3. **Project# 1009243**
13DRB-70587 MINOR - PRELIMINARY/
FINAL PLAT APPROVAL  SBS CONSTRUCTION AND ENGINEERING, LLC agent(s) for SC CAPTIAL, LLC request(s) the above action(s) for all or a portion of Lot(s) 15-A, Block(s) 15, **MESA GRANDE ADDITION** zoned CCR-2, located on 317 WASHINGTON SE containing approximately .2125 acre(s). (K-17) **THE PRELIMINARY/FINAL PLAT WAS APPROVED WITH FINAL SIGN OFF DELEGATED TO PLANNING FOR ADDITIONAL EASEMENT FOR DRIVE ISLE, UTILITY COMPANY SIGNATURES AND AGIS DXF.**

**CITY OF ALBUQUERQUE
PLANNING DEPARTMENT
June 26, 2013
DRB Comments**

PROJECT # 1009243 APPLICATION # 13-70587

RE: Lot 15-A, Block 15, Mesa Grande Addition

**PLAT OF**  
**LOT 15-A-1 15-A-2, BLOCK 15**  
**MESA GRANDE ADDITION**  
**SECTION 23, T10N, R3E N.M.P.M**  
**CITY OF ALBUQUERQUE**  
**BERNALILLO COUNTY, NEW MEXICO**  
**MAY 2013**  
**SHEET 1 OF 2**

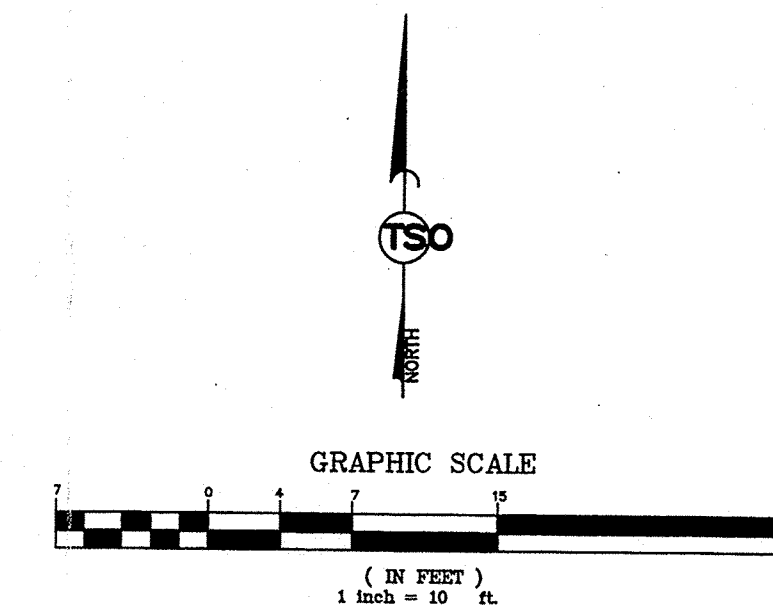
There is a typo in the Legal Description that needs to be corrected prior to filing.

The provided copy of the Common Driveway Easement does not extend as far into the lot as shown on the plat drawing; it appears additional easement area is needed on adjoining Lot 17-A for proposed access easement to work.
